Paul Cann
Principal Engineer (Drainage)

Further to your email dated the 2nd April 2020 to Juan Baeza and David Spring, I would comment as follows.

Please find attached our revised drainage drawing E19-003-1000A and micro drainage calculations along with structural sketch E19-003-SK2000 showing the support to the raised tanks.

## Site Drainage Plan

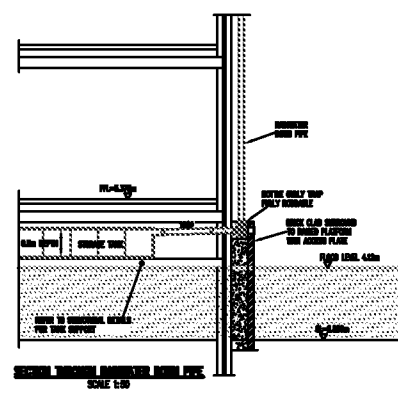
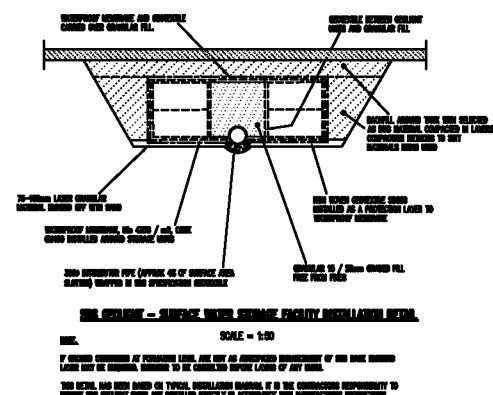
1. Fluvial flood water (designing against the 1 in 100 yr +105% modelled event) will still overwhelm the car park drainage and parts of the roof drainage system (The roof water currently discharges into the system serving the permeable surfaced car park). Consider separating the roof water from the system serving the permeable pavement. I.e. provide at least two separate outfalls (possibly three bearing in mind item 2 below) to the watercourse/s with independent hydrobrakes and flap valves. Sealing all components of the roof water system below 4.12m AOD to prevent fluvial flood water inundation i.e. sealed manhole covers, etc. Accept that the permeable pavement system will be inundated with fluvial flood water, since there is little that can be done to prevent flood water entry. Compensate for this by overdesigning the permeable pavement storage (factor to be agreed).

2. Tank access for maintenance is still an issue. Whilst an attempt has been made to address this, the western tanks having slightly better access than the eastern tanks, however, this still falls short of what is required. Perhaps consider moving the western storage from beneath the building to the area between Ford Rd and the building, ensuring cover levels are set above 4.12m AOD and sealed for good measure? Can this option be achieved? Connect this system independently to the northern watercourse.

3. Suitable access to the eastern tanks –including the orifice control is a challenge. Full safe access is required to all tank sections/link pipes, etc for inspection/cleaning. The fact that access points will be at a height of around 1.5m above ground level is also a key point here and a safe form of access will need to be provided. Whilst a low flow channel and rodding points will provide some help, it is not considered a total solution and

5. All RWP's to connect to tanks at soffit to soffit level and somehow incorporate silt traps (roofs still produce siltation due to leaf fall collected in gutters/moss growing on the roof, etc). Provide a safe means of access to rodding eyes/silt traps.

6. Both systems to store 1 in 100 year event + 40% (without flooding) and designed against a surcharged outfall ie. assume ditch is full to top of bank. Also simulate discharge (roof water systems) against predicted flood level of 4.12m AOD.

7. Details of low flow channel for tanks/gradient/tank material/link pipes to be min 300mm diameter.

Please find attached a copy of drawing E19-003-1000 A which has been revised as follows.

The roof drainage from each building has been separated out from the car park drainage. Each system has its own outfall into the adjacent watercourse. All manholes which have cover levels below 4.12m AOD, will have sealed bolt down covers. The storage tank for the roof water runoff by Ford Road has been set as high as possible to keep the majority above the top of ditch level (2.0m AOD). Therefore should the ditch become surcharged the storage for the roof water runoff will not become inundated. The attenuation below the car park has been sized to suit the car park runoff ignoring the voided stone below the permeable paving. The crates below the car park provide 73 Cu.M of attenuation. The 30% voided stone below the car park will provide approximately an extra 150 Cu.M of attenuation.

Drawing E19-003-SK1000 A indicates a scheme which locates the attenuation outside the building towards Ford Road. The drainage from the roof also has its own outfall to the watercourse. All rainwater pipes have sumps to remove silt and allow easy maintenance.

Drawing E19-003-1000 A and SK2000 show additional details on access and maintenance of the high level suspended tanks. The tank supports are shown in more detail on SK2000. As the majority of the supports are below the tank in the form of a steel plate and secondary beams. The primary beams span to supporting walls. All the steel structure will be galvanised. This layout will allow plenty of safe access to maintain the tanks. The tanks themselves will be sectional steel tanks which will be bolted together insitu. They can be jettied out and cleaned. If required they can also be unbolted cleaned and put back together. Each of the tanks will have plates welded inside to create 'V' shape in the base to form a low flow channel. All the rainwater pipes will have external high level gully set above the flood level. This will take the form of a brick column with a cover which can then be removed to allow access to the gulley. A detail has been shown on drawing SK1000 A. The roof of the block is designed to emulate a traditional sloping tiled roof. Whilst there is a small flat roof area, taking account of the necessary roof penetrations, including an automatic opening smoke vent (AOV) renders a "blue roof" impractical.

All the RWP's are now shown connection to the soffit of the tanks. Silt traps are shown as noted above. The silt traps and rodding eyes are set 1.5m above ground level, (about shoulder height). This means they are accessible from ground level. If higher access is required a small scaffold tower can be used.

The watercourse has been taken as surcharged and a proprietary Checkmate valve shown. Details are attached with the micro drainage calculations for the surface water drainage.

Details have been added to drawing E19-003-1000 A in terms of the tank type, gradients and low flow channels.

Site Drainage Plan

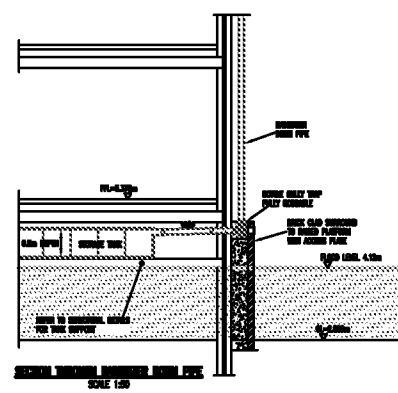
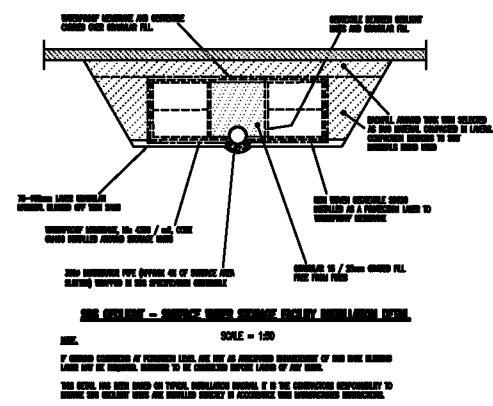
1. System no.1 (adjacent Ford Road) arrangements are now much improved.
2. Two RWP's are connecting into the permeable pavement from the refuse store – can these be connected into the hydrobrake chamber associated with outfall no.1. We looked at connecting the rainwater pipes noted to outfall 1 but the levels don't allow it. The ground is at 2.8m AOD, but the water level in the attenuation connected to outfall 1 is at 3.5m AOD. Detail design may allow a deep flow gutter to be used and allow these rainwater pipes to be moved to a more suitable location or omitted. Predicted water level and proposed ground levels noted. It may be possible to connect these RWP's into outfall no.1 via a sealed system arrangement/non return valve, and potentially increasing the storage in outfall no.1 system to allow for the additional flows. Of course, this is not ideal. Whilst the potential flows are not huge, every effort should be made to remove them from the permeable pavement system (which as we know will be inundated in certain fluvial flood conditions). On this occasion, I would be happy for you to investigate other solutions as part of the detailed design.

3. Tank beneath building;
 - a) It is noted that the tank has had the orifice removed and now relies on a 150mm outlet, low level hydrobrake and sealed system to operate. The sealed part of the system will need to be very robust. Agreed. Ok

- b) Bolted steel tank sections noted but unclear how it will be possible to unbolt them, particularly any bolts on the upper rim of the tank ie. below floor/void. Yes this needs more detailed consideration with a tank supplier/fabricator. We have also looked at designing a system where the tanks can be lowered to allow access. Access into the voids is very good as the base level is down at 2.8m AOD. The primary members could be designed with a splice in them which would allow a hydraulic winch stacker (similar to that used to install steel beams in buildings), to lower the platform and tank down allowing much better access. This needs some detailed design which would be best conditioned to allow a detailed solution to be sorted. Agreed

- c) Tanks would need to be protected against corrosion both inside and out. Agreed. The tanks will need to be galvanised inside and out along with any steel support structure. Ok

- d) The upstream rodding point is shown on the section but not on the plan. Specify as 300mm diameter pipe. We have amended the plan to show the pipe as 300mm in diameter. Ok

e) Show tank gradient on section. The tank gradients have been shown on the plan. I can't identify the actual gradient, however, I am happy to leave this to the detailed design. Just be aware that a reasonable fall will be expected.

e) Access is still considered an issue and needs to be addressed further. My suggestion; In addition to the rodding points, can man entry access be made into each tank? I.e. side entry via hatch with appropriate water tight pressure seals/wheel handle/etc i.e. similar to what you can get on marine vessels. We can look at providing access panels to the sides of all the tanks in conjunction with the notes for item (b) above. Again this needs some detailed design input from a manufacturer/fabricator and as with (b) above could perhaps, be conditioned. Noted, and agree it can be conditioned. The essential thing here is that you are now fully aware that the access needs to be greatly improved and some reasonable ideas have been batted about. It will now come down to the detailed design.
